SPR EA1N and EA2 PROJECTS

DEADLINE 2 – COMMENTS ON EXQ1 RESPONSES - 1.8 HISTORIC ENVIRONMENT

Interested Party: SASES

Figure 5: Outline Landscape Mitigation Plan and Relevant Heritage Assets in the vicinity of Friston

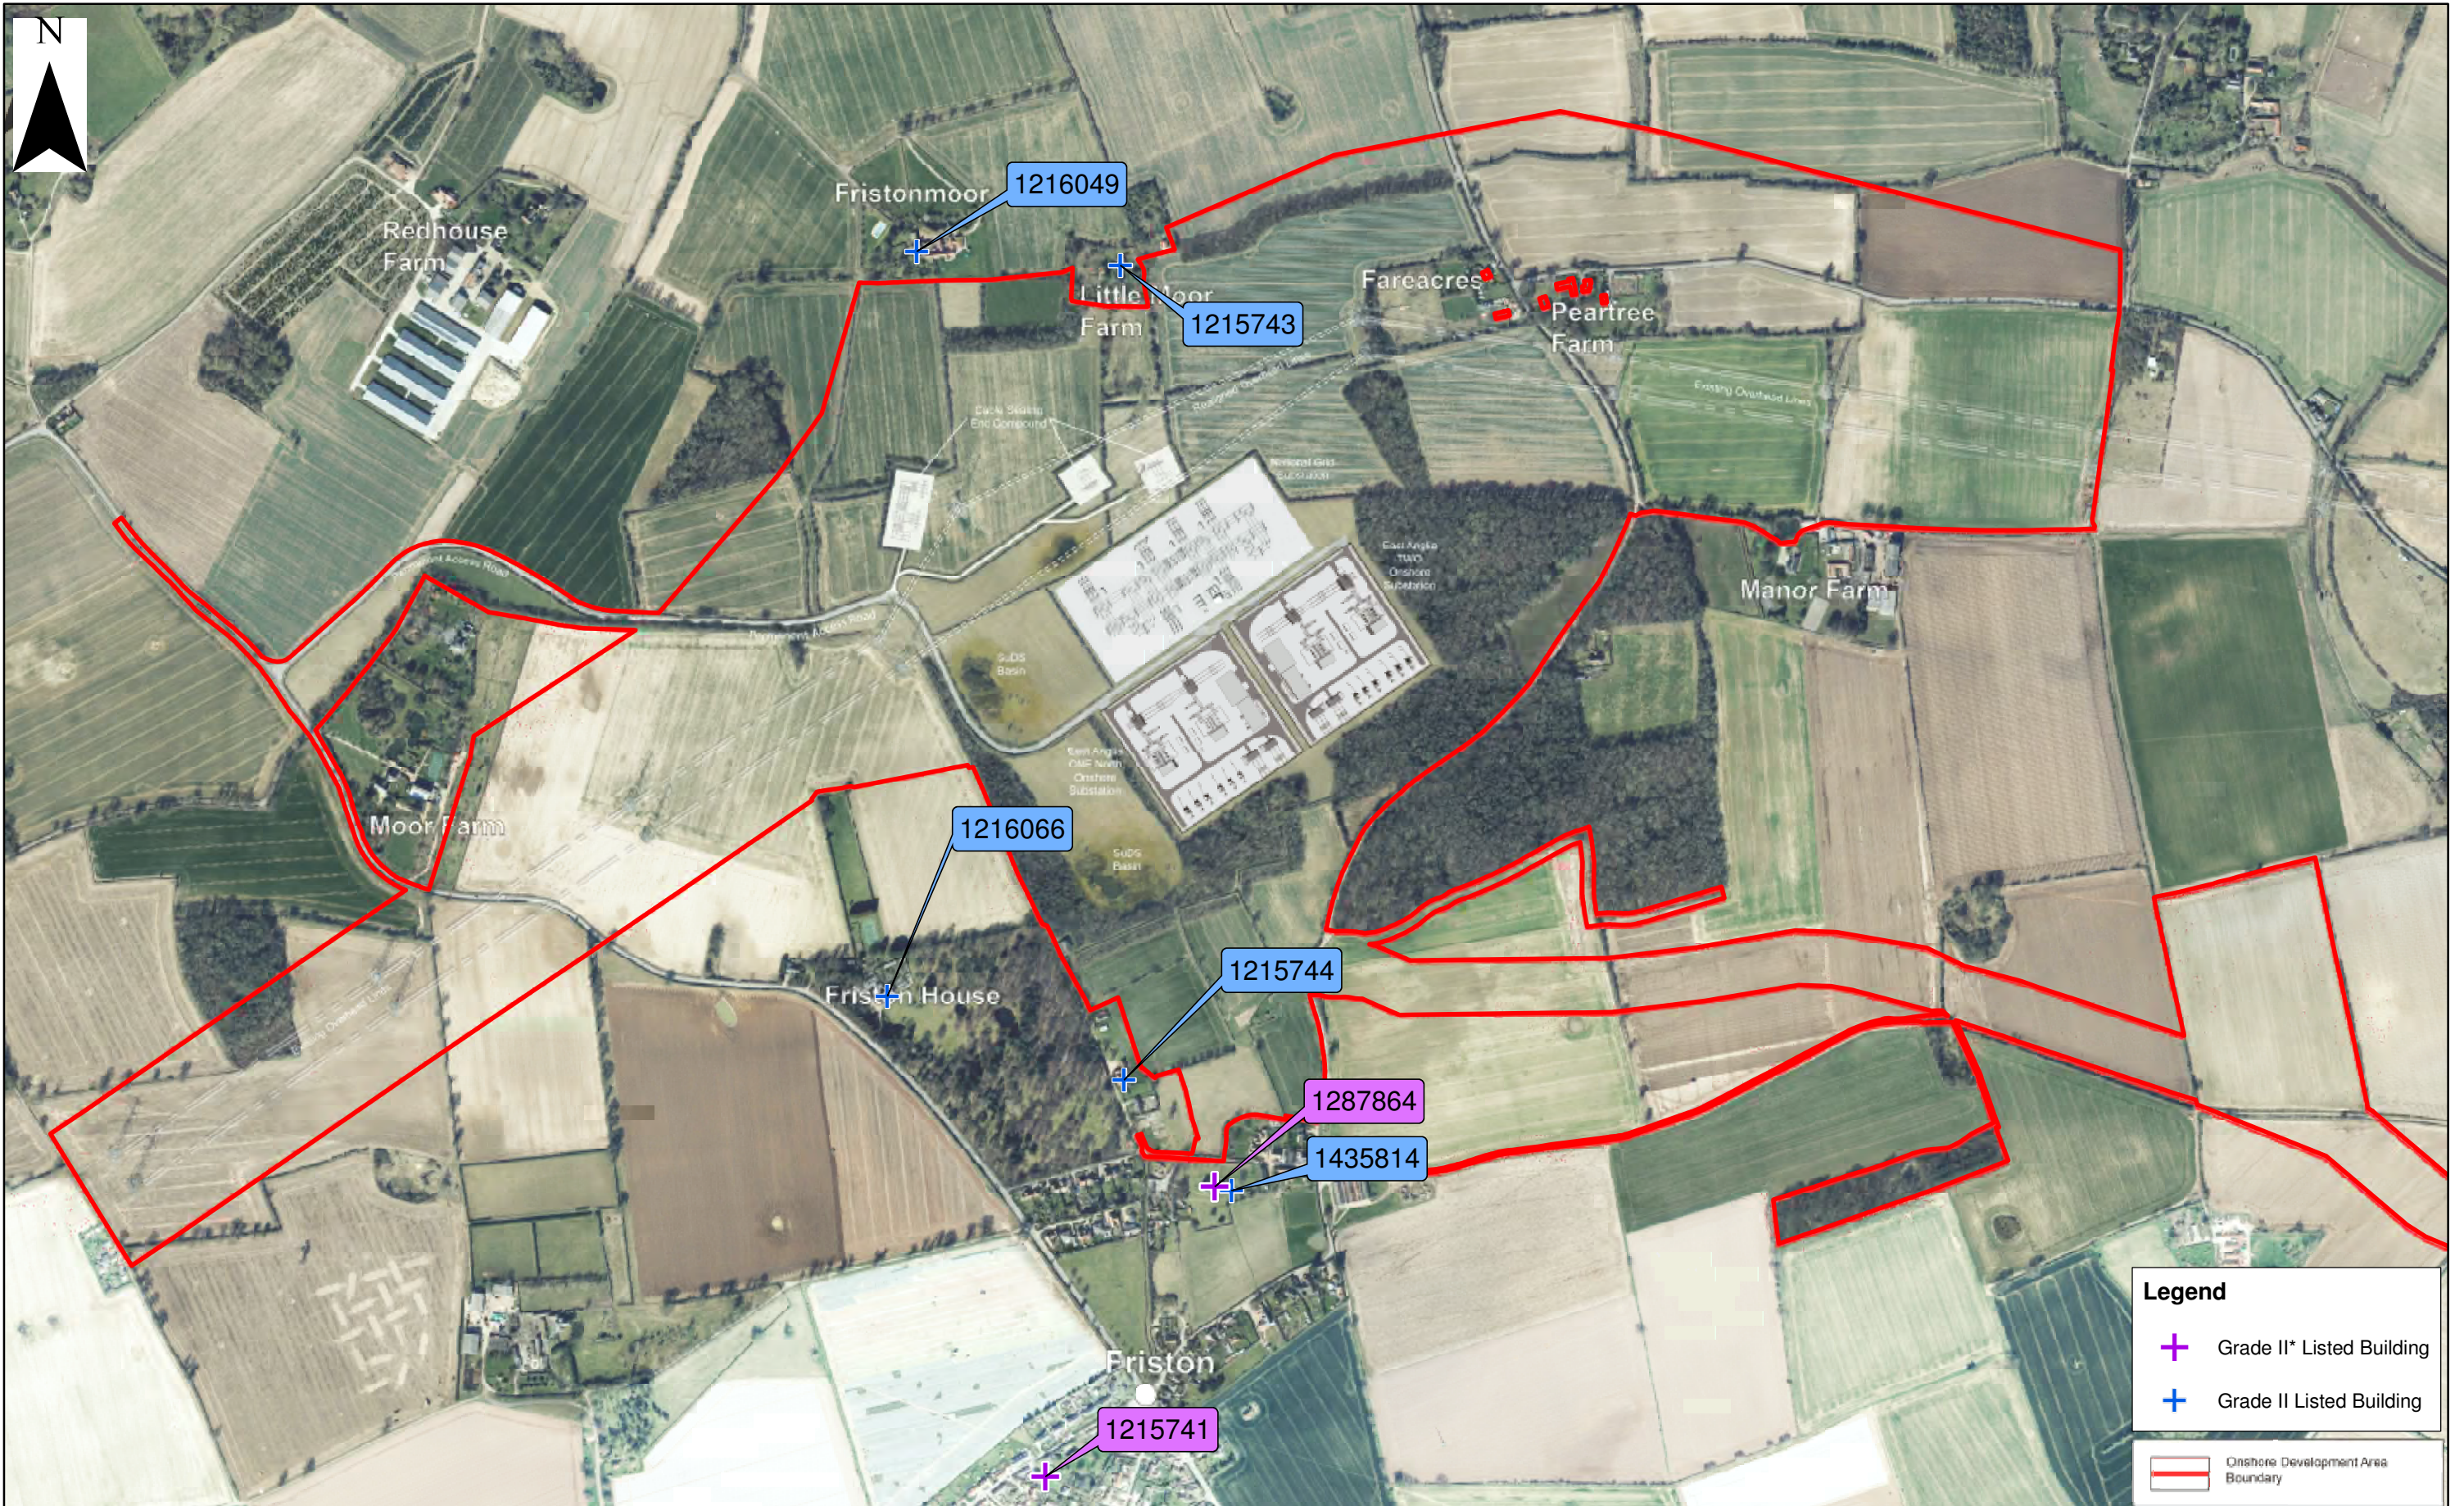
landscaping scheme in relation to the heritage assets, particularly in relation to Little Moor Farm and Woodside Farmhouse.	
1.8.10	<p>Mitigation – Church of St Mary</p> <p>It is acknowledged that proposals in the OLMP [APP-401-403] will not reduce the adverse impact caused by the loss of the views from the north and that, although new paths will be created to compensate for the loss of existing rights of way, none of these are likely to provide new views towards the church tower that might compensate for the loss of views from the north.</p> <p>a) Given this do you consider that the proposed mitigation provides any benefits to mitigating the key impact of the proposed developments upon the significance of the heritage asset?</p> <p>b) Were any alternative schemes considered, including the layout of buildings and compounds; creating new landforms or new landscape which would maintain views towards the Church from the north, as stated to be sought in the design of the OLMP?</p>	<p>The Applicant’s site selection process was flawed see SASES Written Representation on Site Selection.</p> <p>In any event it does not justify the selection of the site as the ‘least bad’ option. “It is still bad, but it could be worse” is not a justification.</p>
